Report title:	Stage 1 Road Safety Audit Lowfield Road Railway Bridge Signalisation
Date:	December 2021
Document reference and revision:	211214-MM-Lowfield Road RSA 1
Prepared by:	Road Safety Initiatives
On behalf of:	Gleeson Regeneration And Homes

Project:	Proposed Residential Development, Land off Lowfield Road, Bolton upon Dearne – Phase 3
Report title:	Stage 1 Road Safety Audit Response Report
Prepared by:	
Name:	Martin Crabtree
Position:	Associate
Signed:	
Organisation:	Bryan G Hall
Date:	15 th December 2021
Approved by:	
Name:	James Pointon
Position:	Director
Signed:	
Organisation:	Bryan G Hall
Date:	15 th December 2021

This is the designers Response report for the Stage 1 Road Safety Audit dated 14th December 2021 for the proposed highway works to signalise the Lowfield Road Railway Bridge as part of the Proposed Residential Development, Land off Lowfield Road, Bolton upon Dearne – Phase 3.

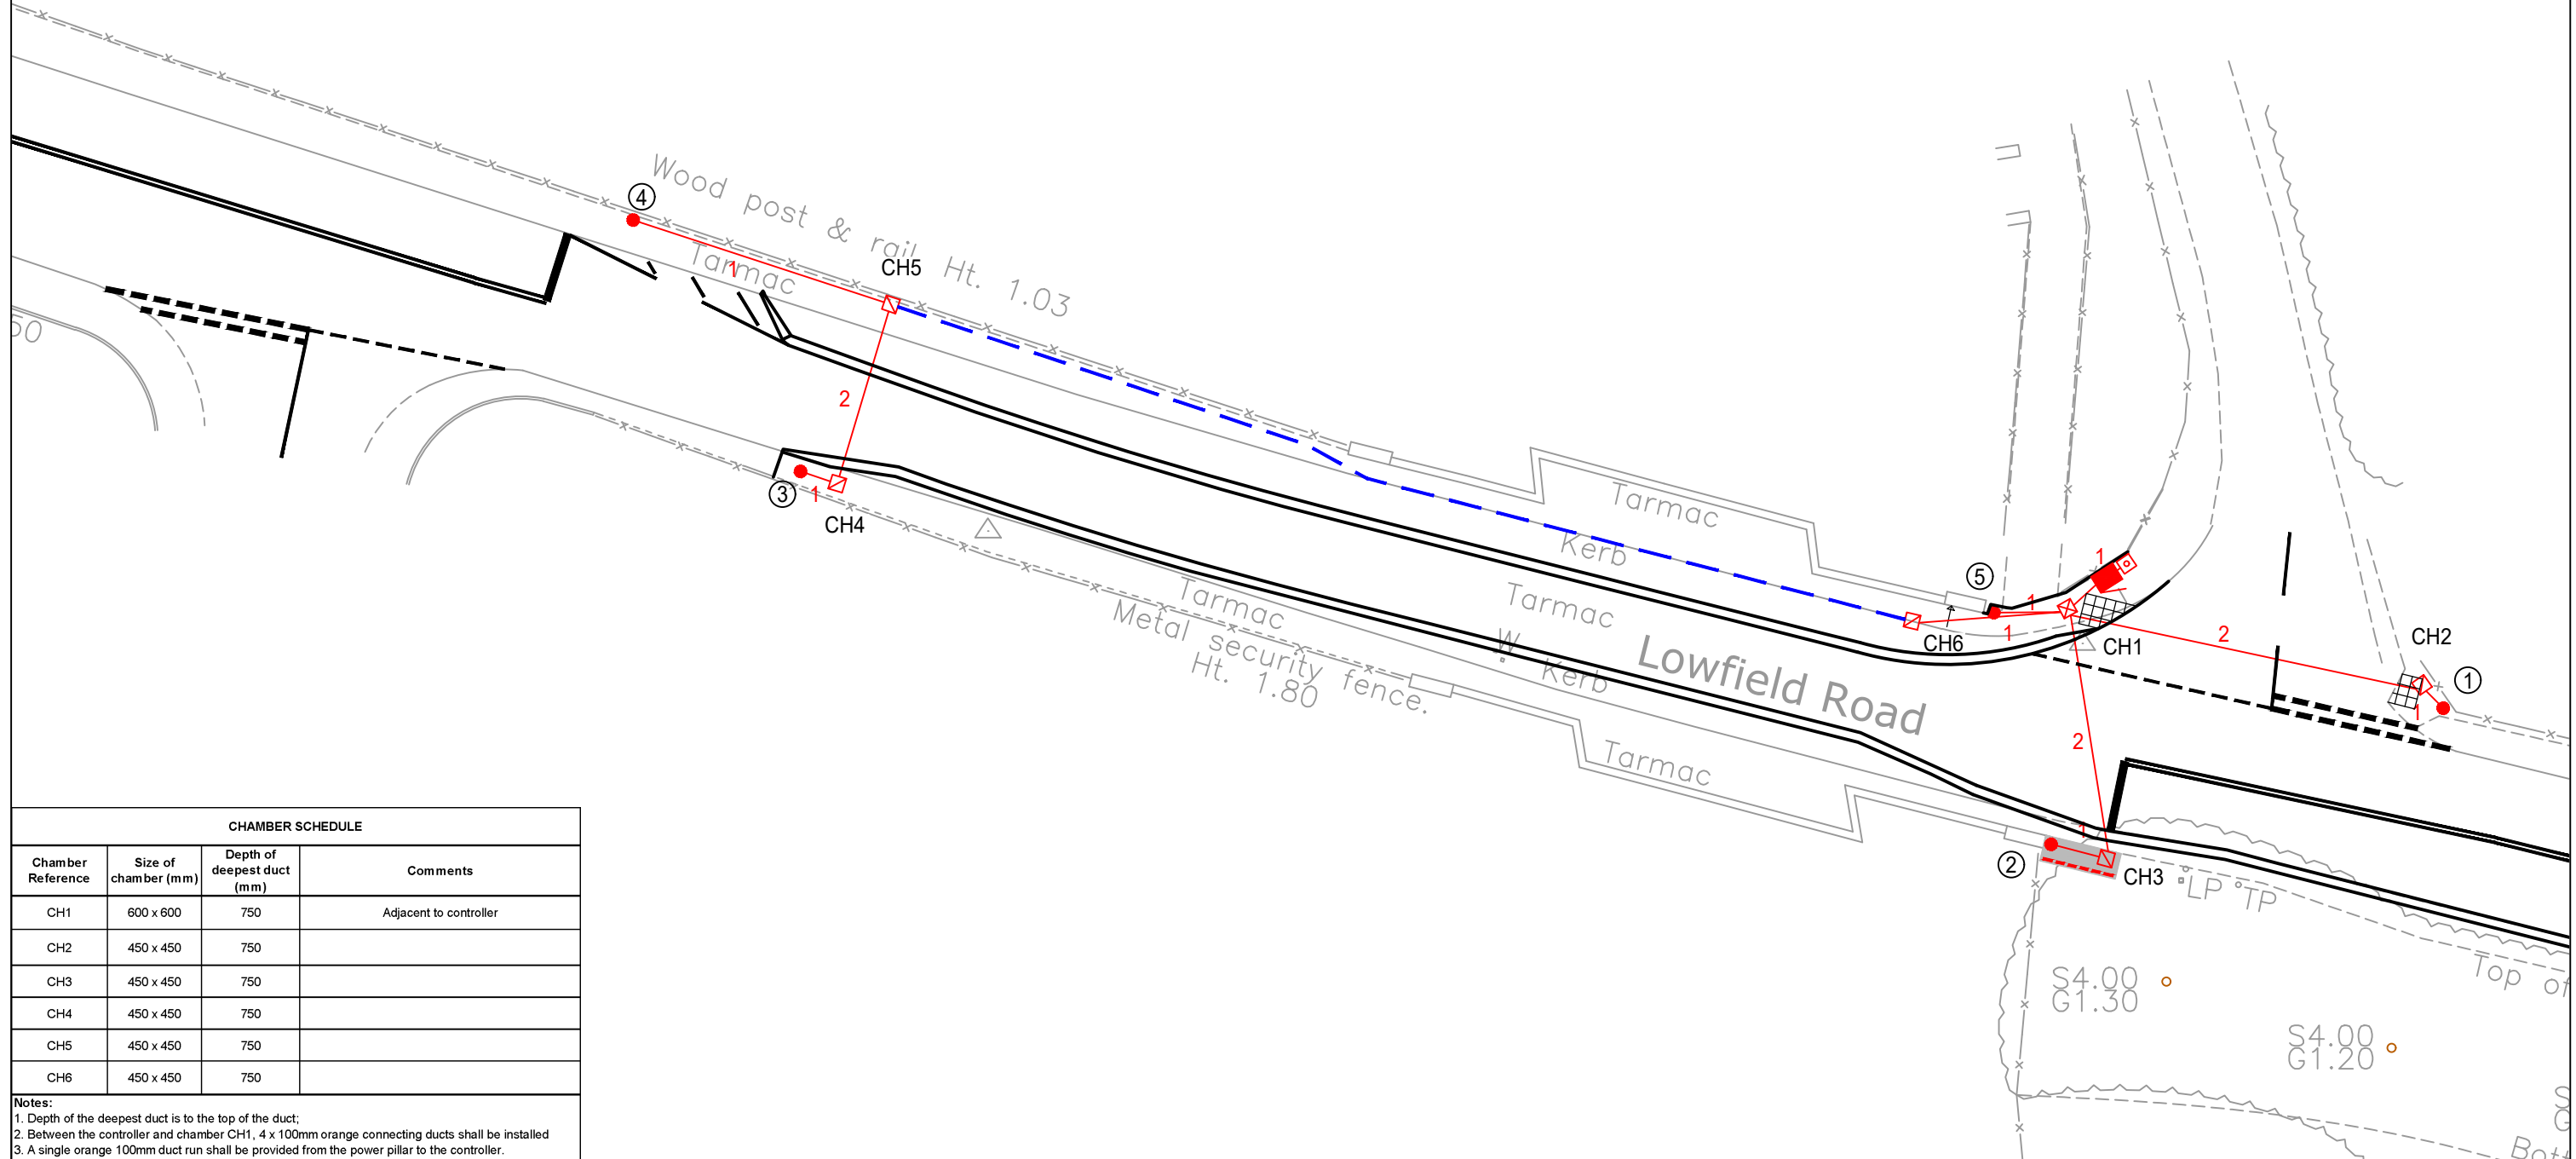
<p>Problem 2.1.2: Potential for overtaking and head-on conflicts.</p>	<p>It is recommended that the risk of overtaking is mitigated e.g., by providing 'prohibit' double-white-lines along both approaches to the traffic signal stop lines.</p>	<p>The proposed scheme has been updated to show 'prohibit' double-white-lines along both approaches to the traffic signal stop lines on drawing numbers 20/237/DE/1300/001 Rev B and 20-237-DE-1300-002 Rev B.</p>

<p>Problem 2.2.1: Potential for a conflict involving a cyclist and an overtaking vehicle.</p>	<p>It is recommended that there is a mitigation measure for the potential 'squeeze' problem for cyclists. The running lane could be made narrower so that vehicle drivers were discouraged from trying to pass cyclists or made wider to allow for safe overtaking. Suitable warning signs or markings could also be provided.</p>	<p>The proposed scheme has been updated to show a 3.0m running lane in line with LTN1/20 across the bridge to allow cyclists to take up the primary position and to discourage vehicle drivers from attempting to pass a cyclist on drawing numbers 20/237/DE/1300/001 Rev B and 20-237-DE-1300-002 Rev B.</p> <p>Suitable warning signs or markings will be provided and agreed at the detailed design stage.</p>		
<p>Problem 2.2.2: Potential for a conflict involving a pedestrian crossing the access road.</p>	<p>It is recommended that a safe, accessible, and convenient crossing is provided across the un-named access road.</p>	<p>The proposed scheme has been updated to show amendments to the footway on the south side together with dropped kerbs and tactile paving on drawing numbers 20/237/DE/1300/001 Rev B and 20-237-DE-1300-002 Rev B.</p>
